Our Case Number: ABP-318607-23

Re: Proposed construction of a residential led mixed use scheme across 16 blocks within 9 buildings ranging in height from 4 to 15 storeys
Lands at Park West Avenue, Cherry Orchard Dublin 10. Bound by Cloverhill Road to the north, Cedar Brook Avenue and Park West Avenue to the east, Park West Cherry Orchard Rail Station to the southeast & the M50 to the west

RE: Case Reference JA29N.318607 - Part X Application by the Land Development Agency on behalf of Dublin City Council for a Residential Development at Park West / Cherry Orchard

The National Transport Authority (the “NTA”) has reviewed the above referenced planning application and, based on the Transport Strategy for the Greater Dublin Area 2022-42 (the “Transport Strategy”), which is a consideration material to the planning process in the Greater Dublin Area, make the following observations and recommendations.

Title
PROPOSED ROAD JUNCTION SIGHTLINES

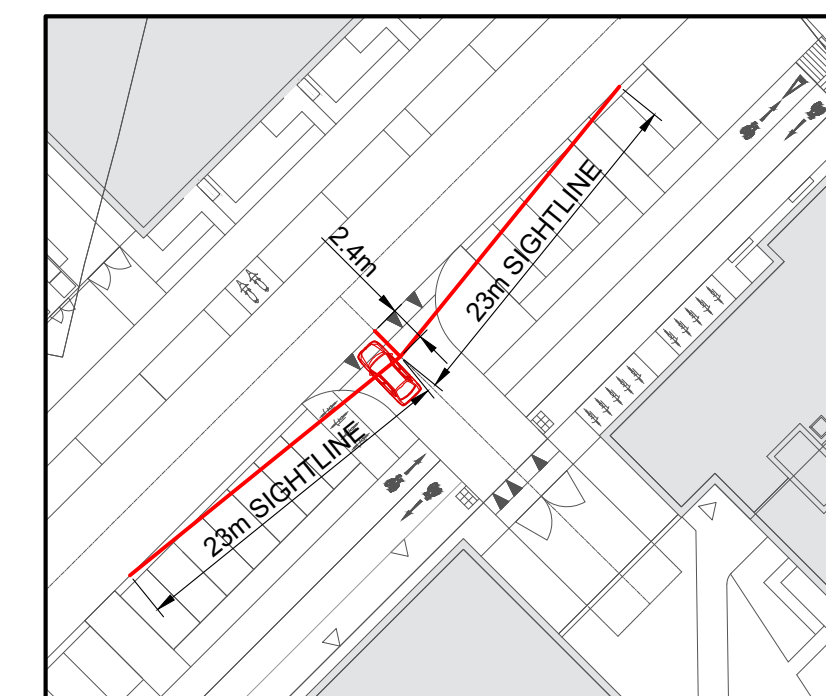
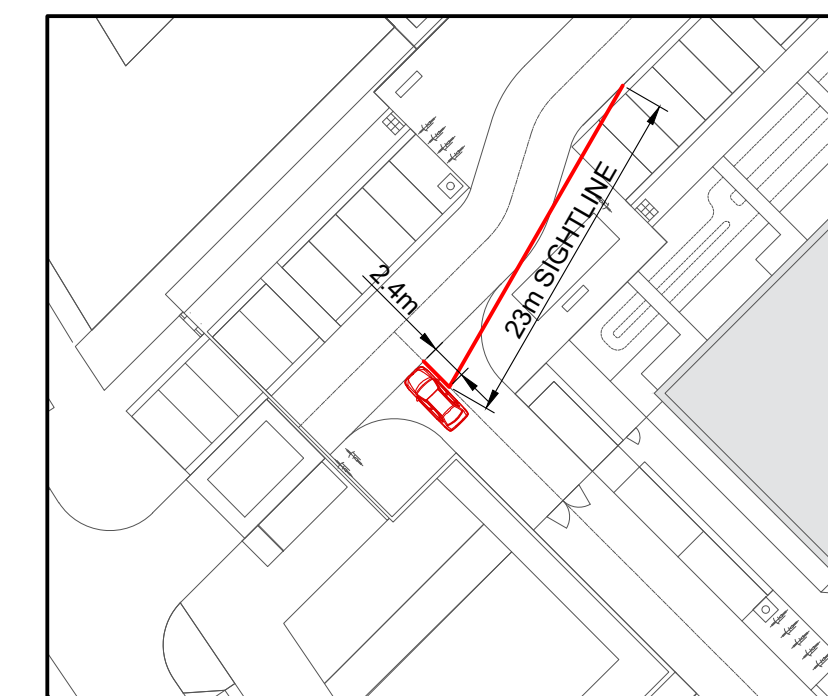
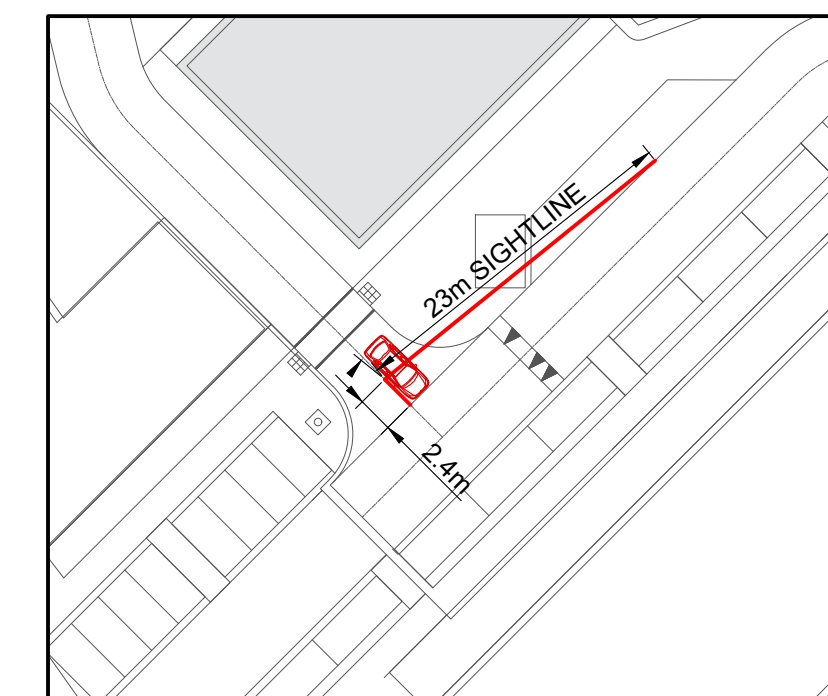
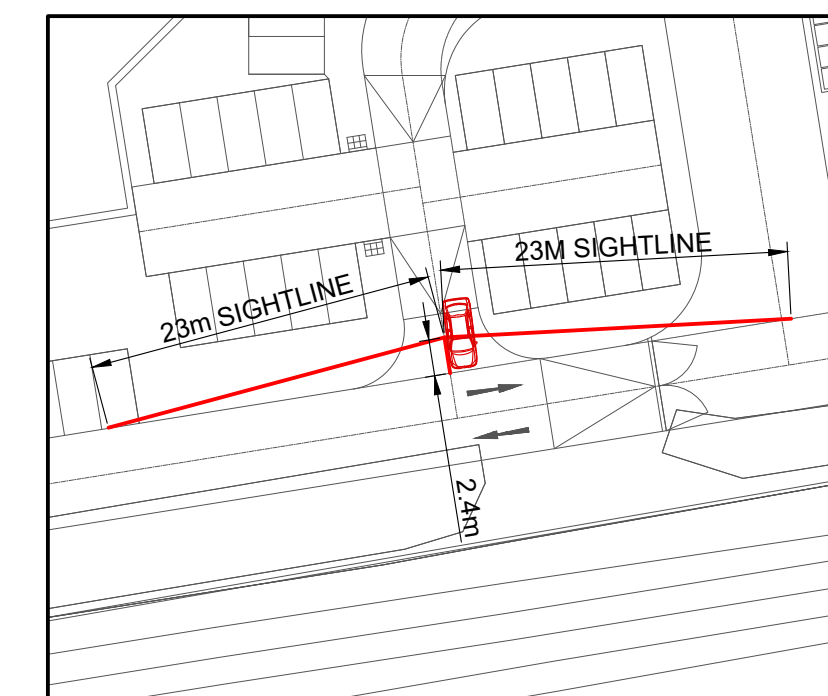
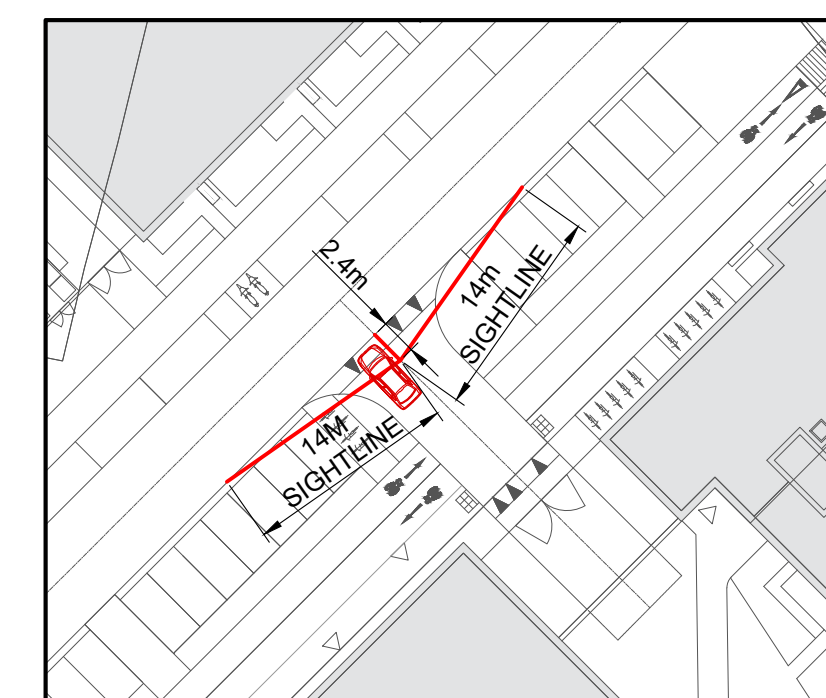
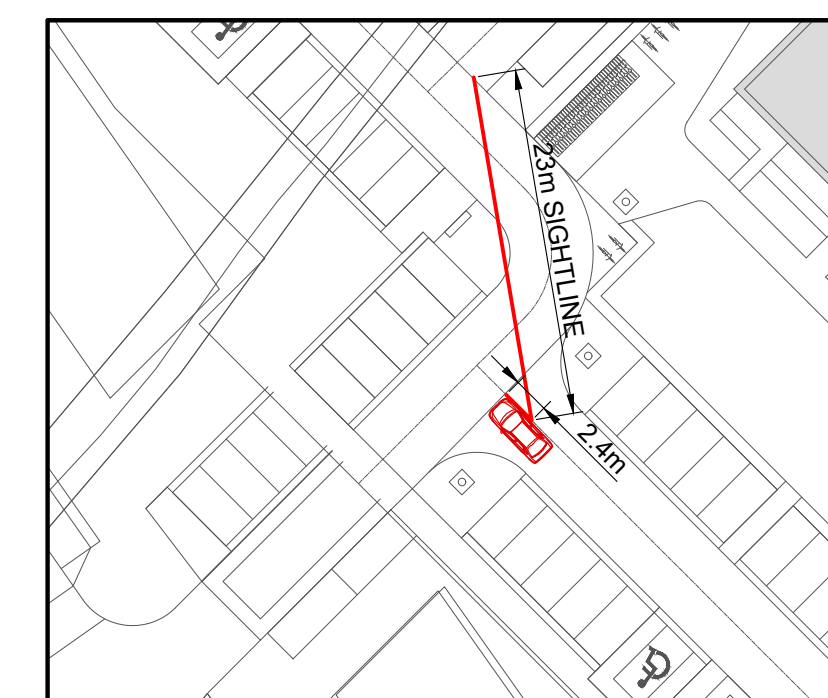
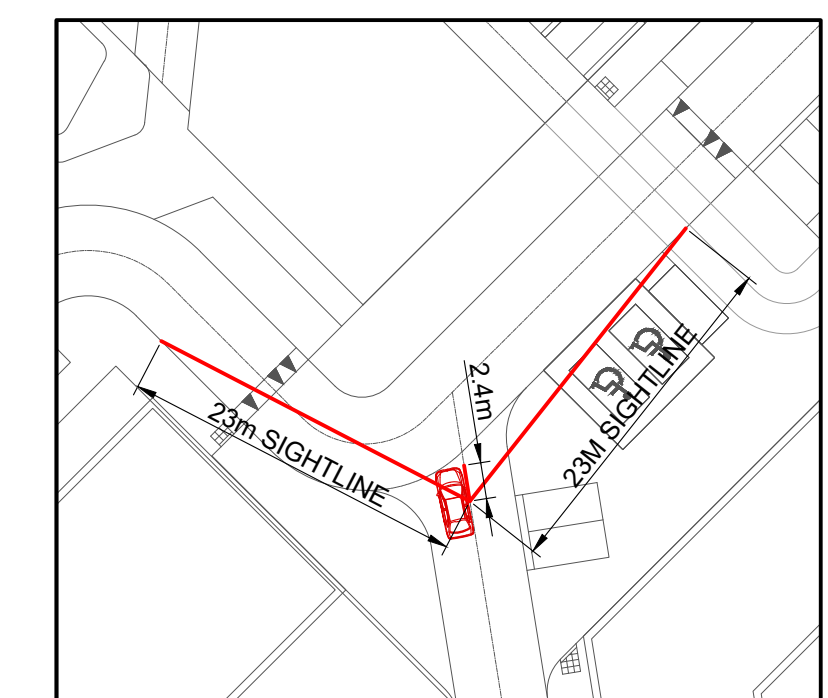
The NTA notes the proposed design of the access junctions and is of the view that designs which reflects the Cycle Design Manual, published by the NTA in 2023, would be more appropriate in the interests of maximising convenience and safety for cyclists and for attracting new cyclists.

The NTA recommends that, in the event of a grant of permission, a condition is attached requiring the applicant to agree designs for the access junctions with the local authority, which are consistent with the Cycle Design Manual.
